RE: Mercerwood – First Review
Blueline Job No. 20-410

This letter is in response to your review of the Mercerwood project. The plans have been revised per the comments in your letter dated 02/09/2022. Below is a list of each comment with our responses in bold.

Drainage Report

SHEET NAME:
SP-01

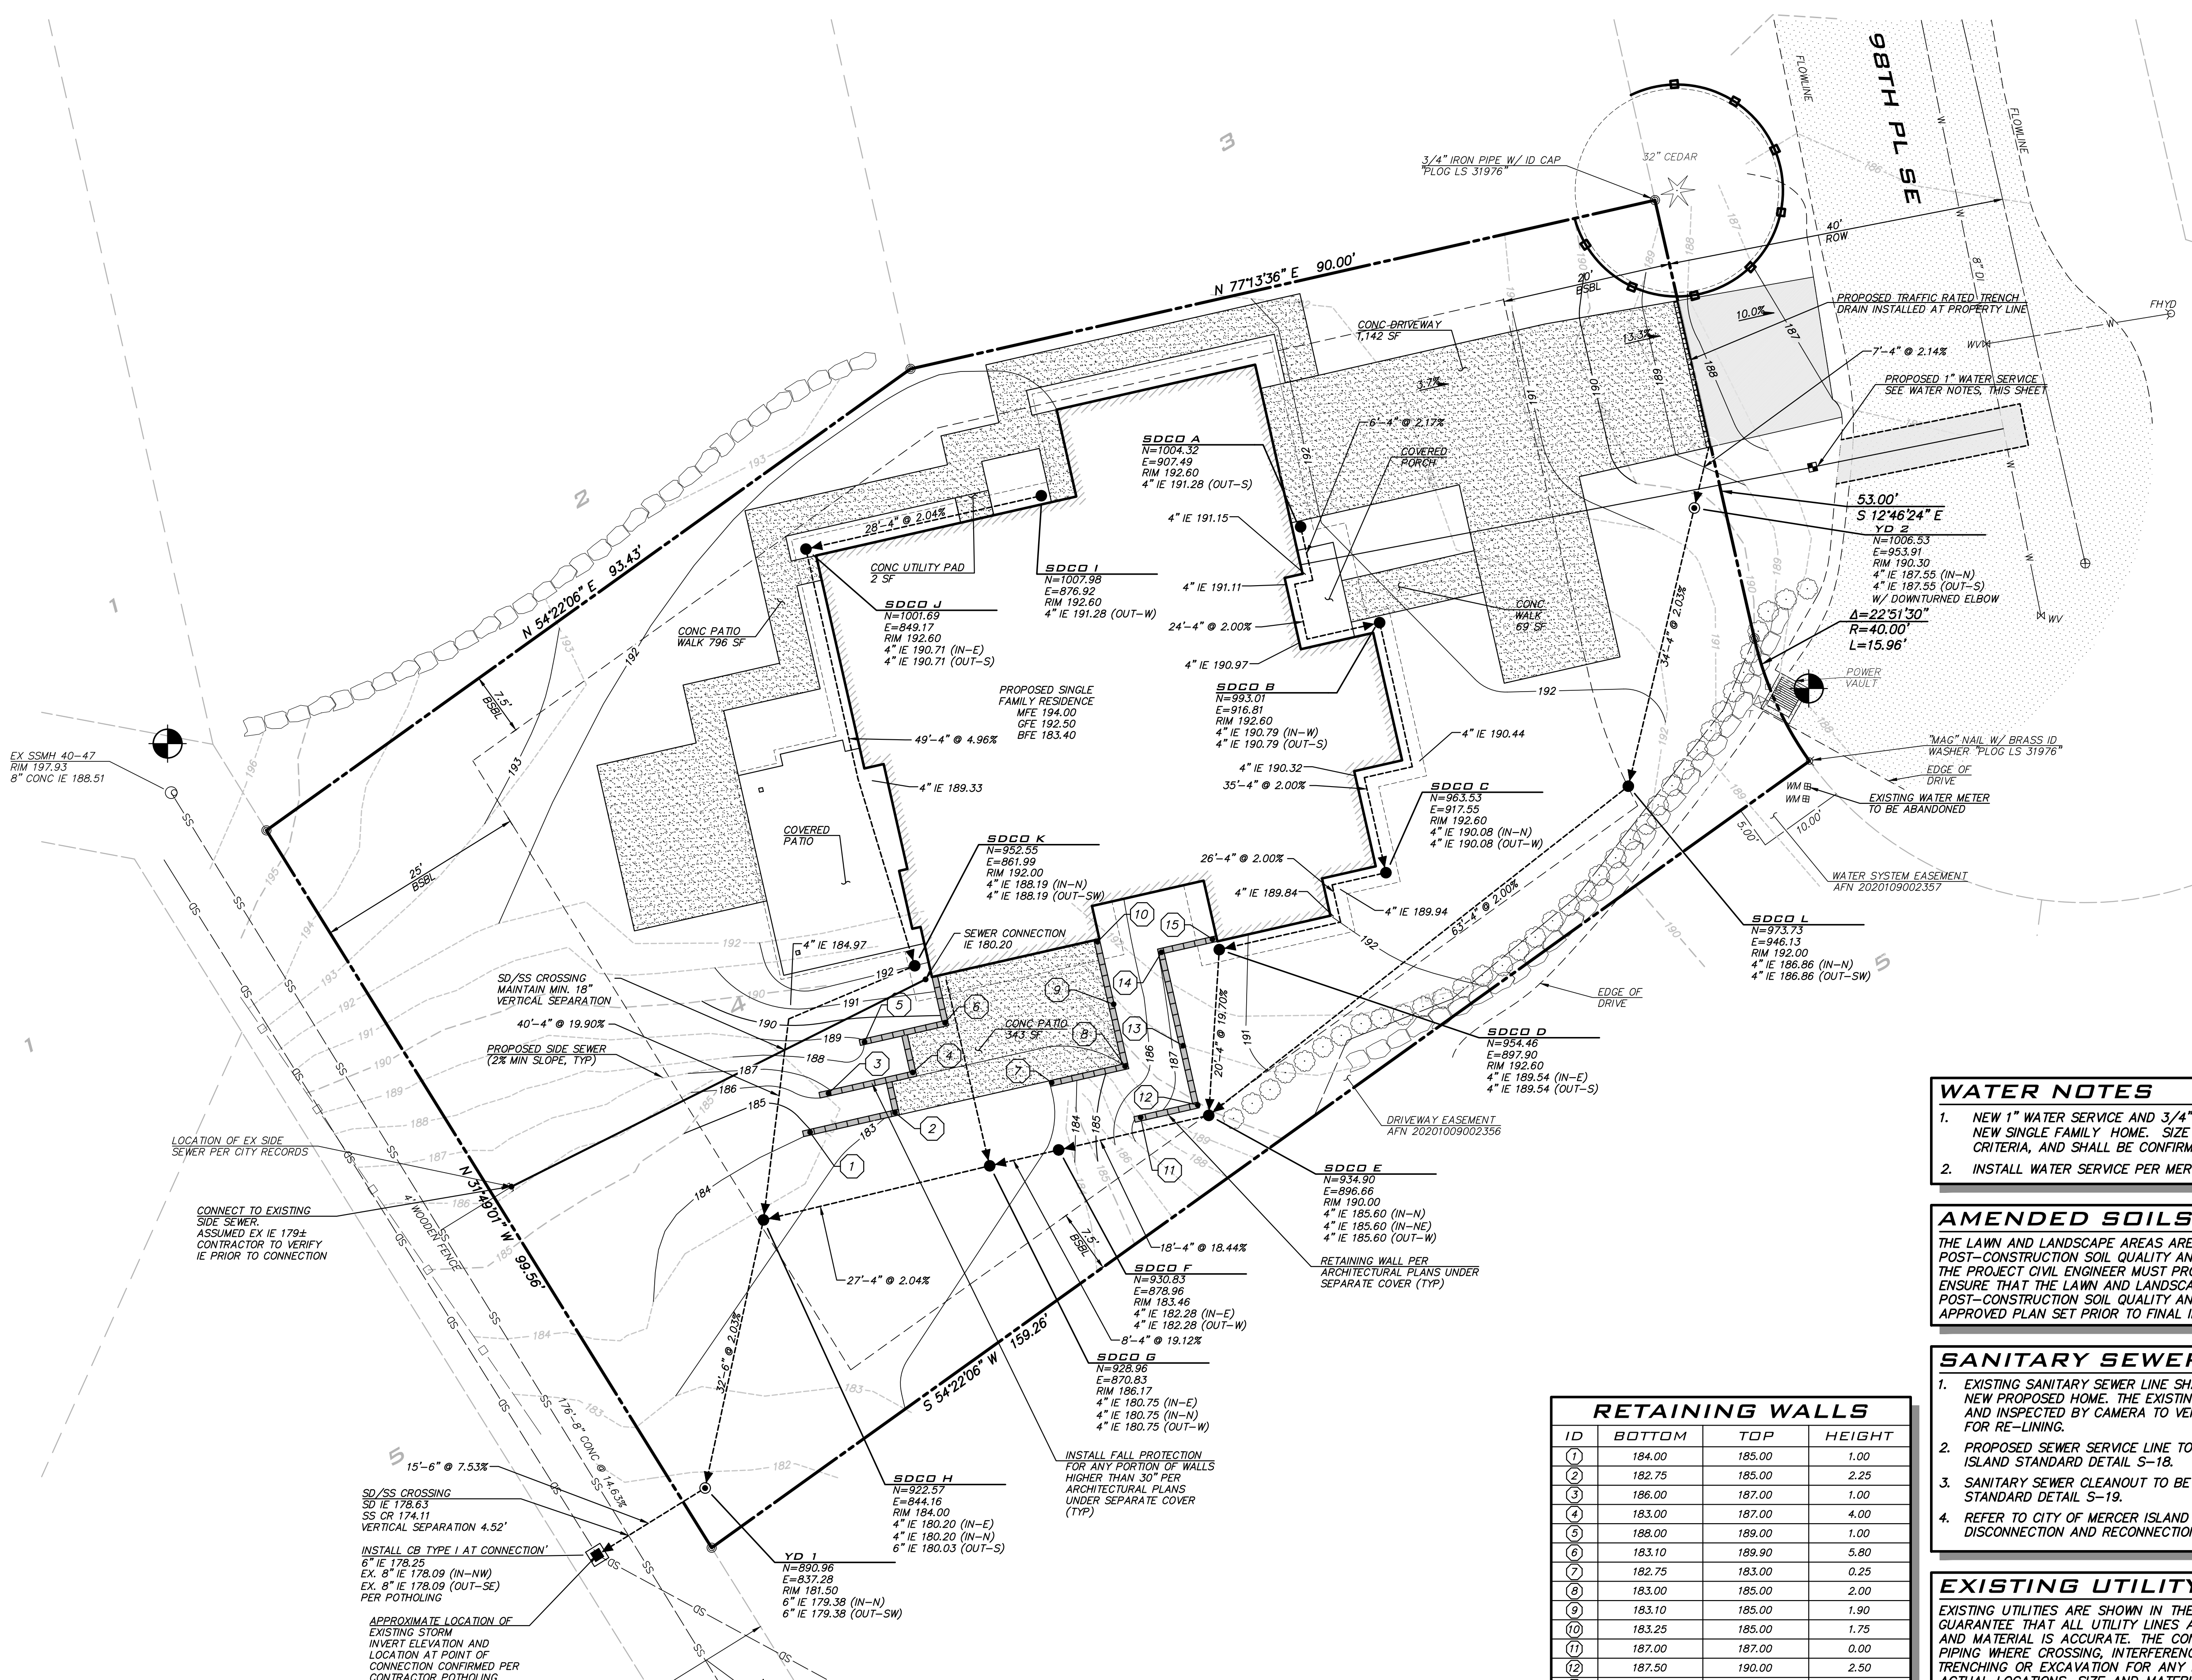
5. This design is not on the drainage plan.

The report has been updated to reflect the infeasibility of perforated stub-out connection.
